ENG-SF21021-R1-FDR.pdf Markup Summary

Subject: EPC ENG Review
Page Index: 1
Date: 7/6/2021 8:29:53 PM
Author: dsdrice
Color: ■
Layer:
Space:
Page Label: 1

Sand Creek Impro CL-PR

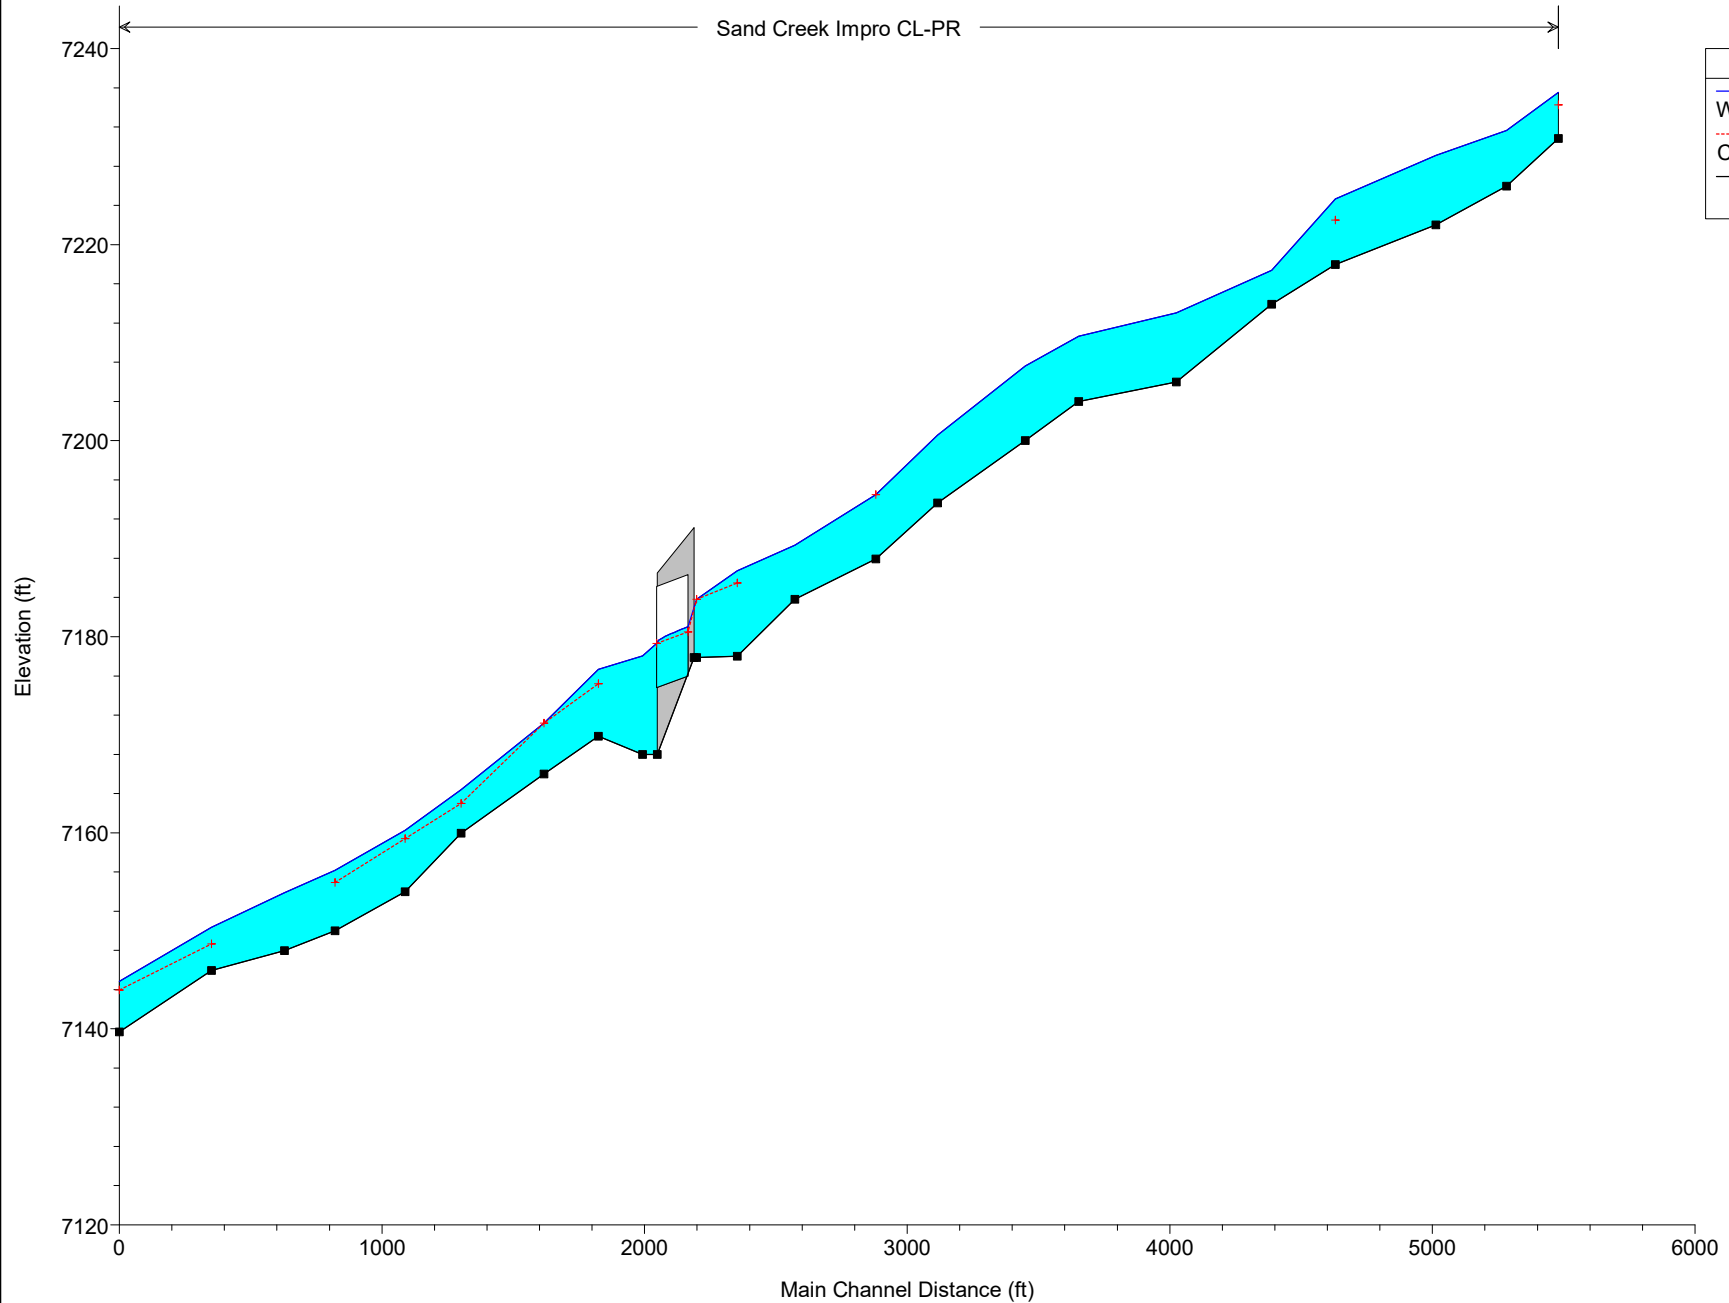
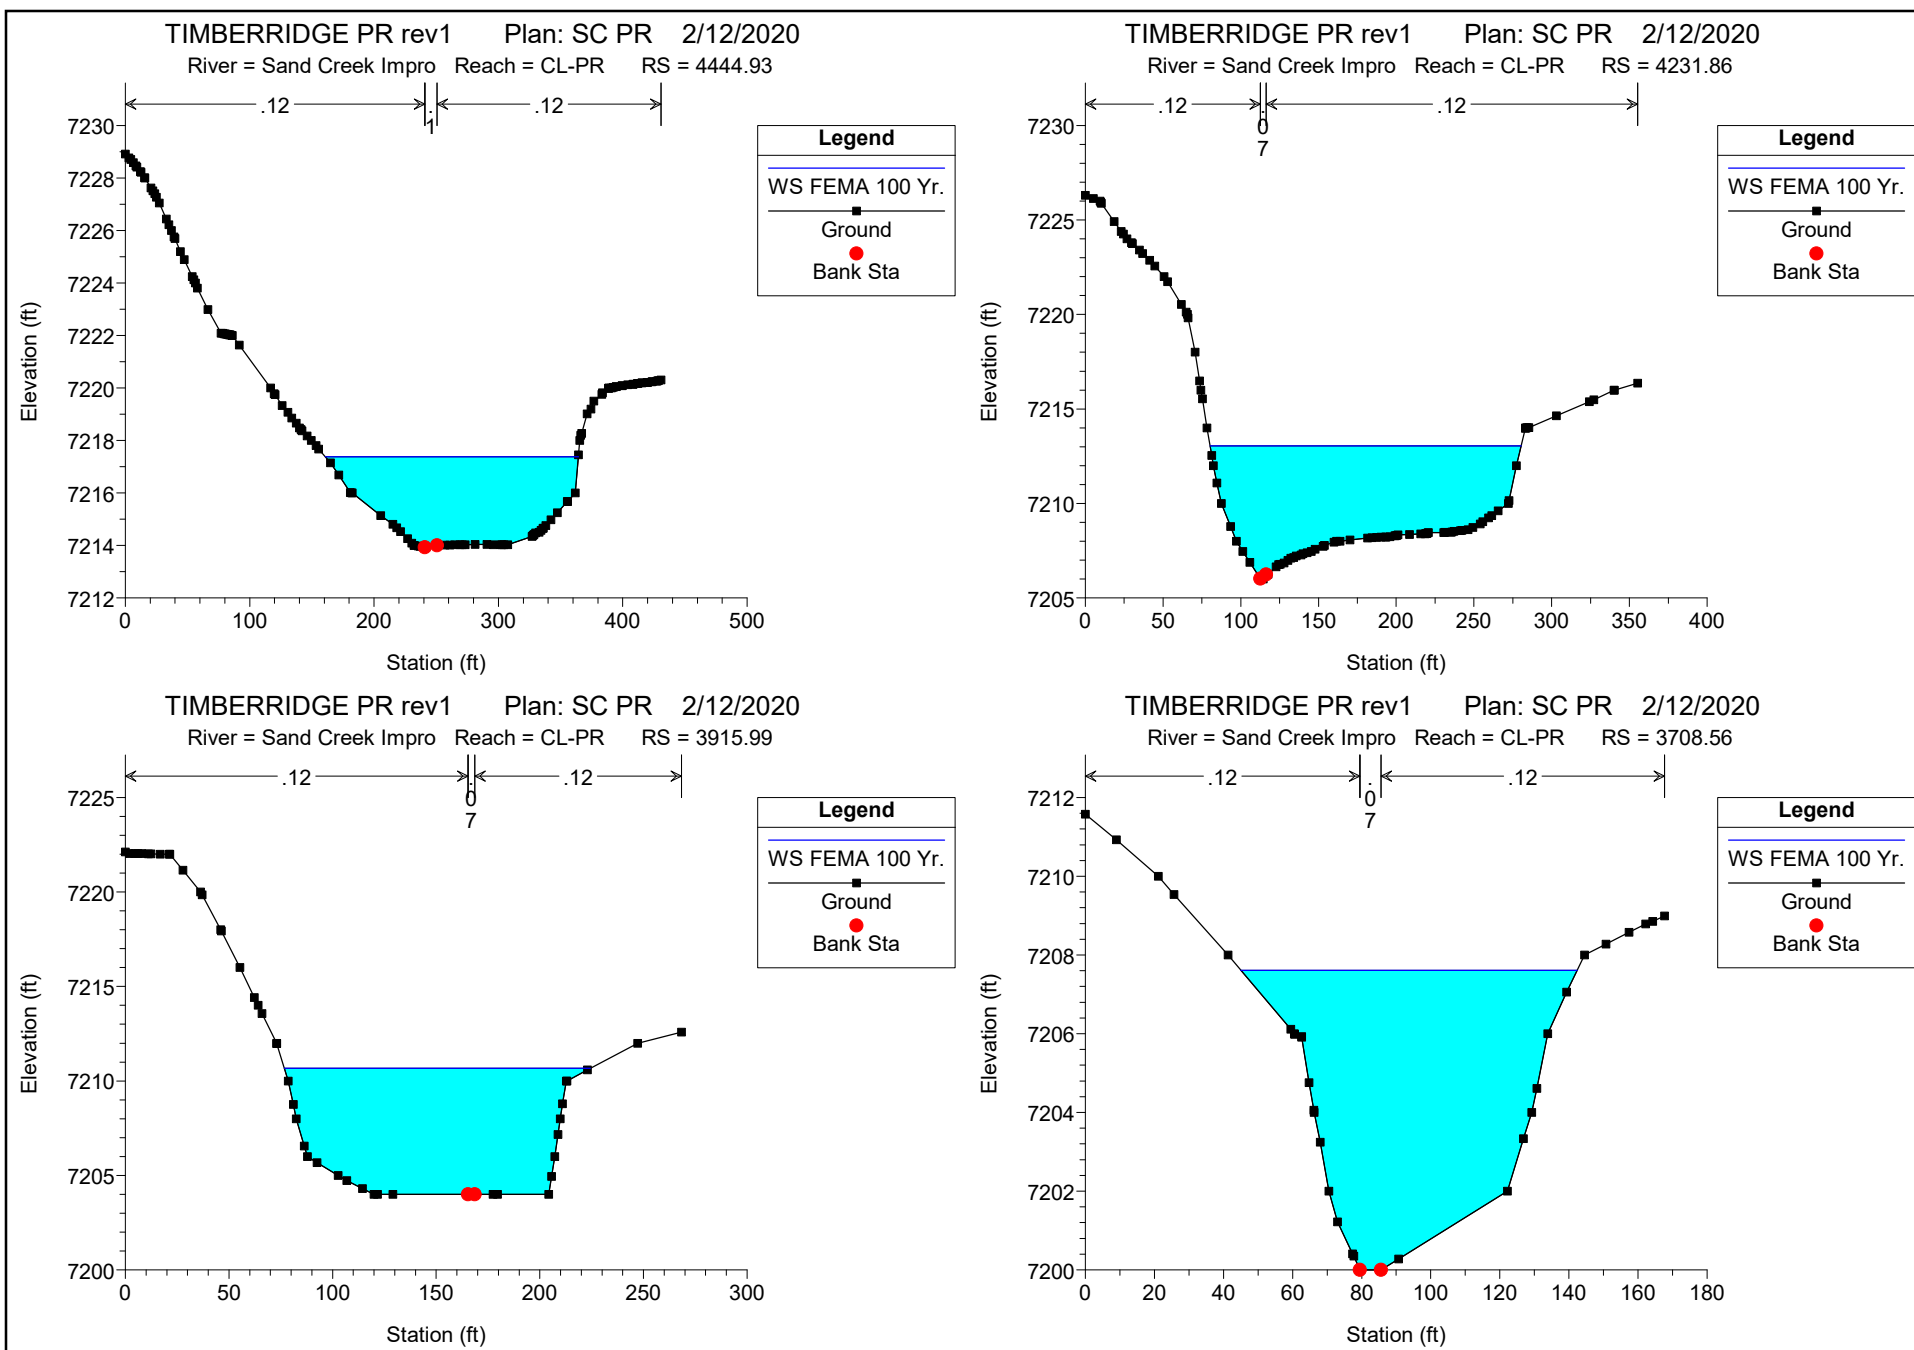
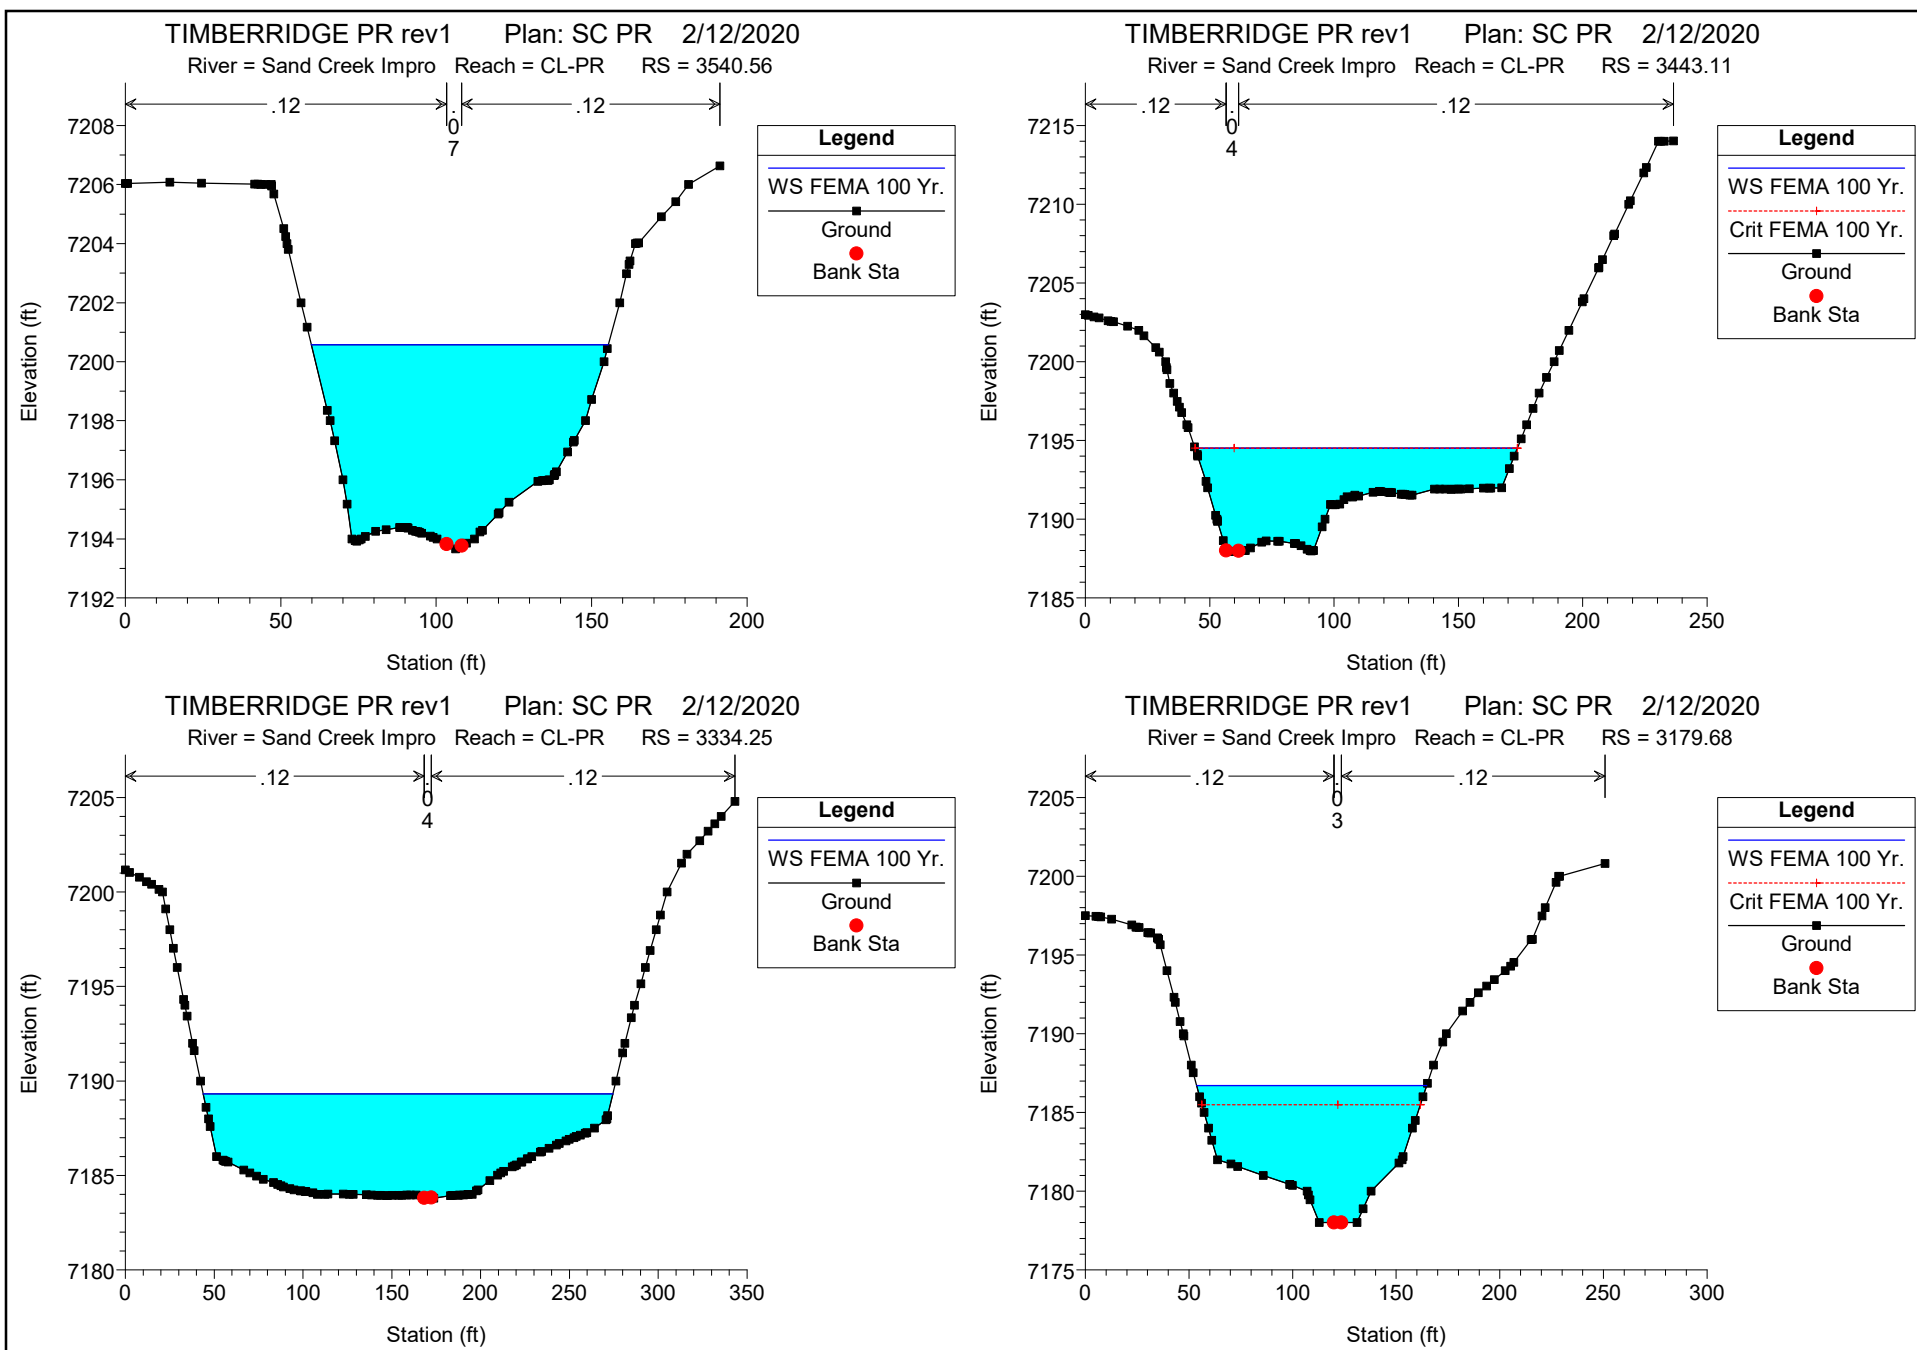
This is next to Lot 13 - if the channel is anticipated to drop 5' in this location additional protection is needed.

How did the channel drop 5 feet? If this model is "future, post-erosion, it needs to be labeled as such. Do the check structures allow for 5' of erosion?
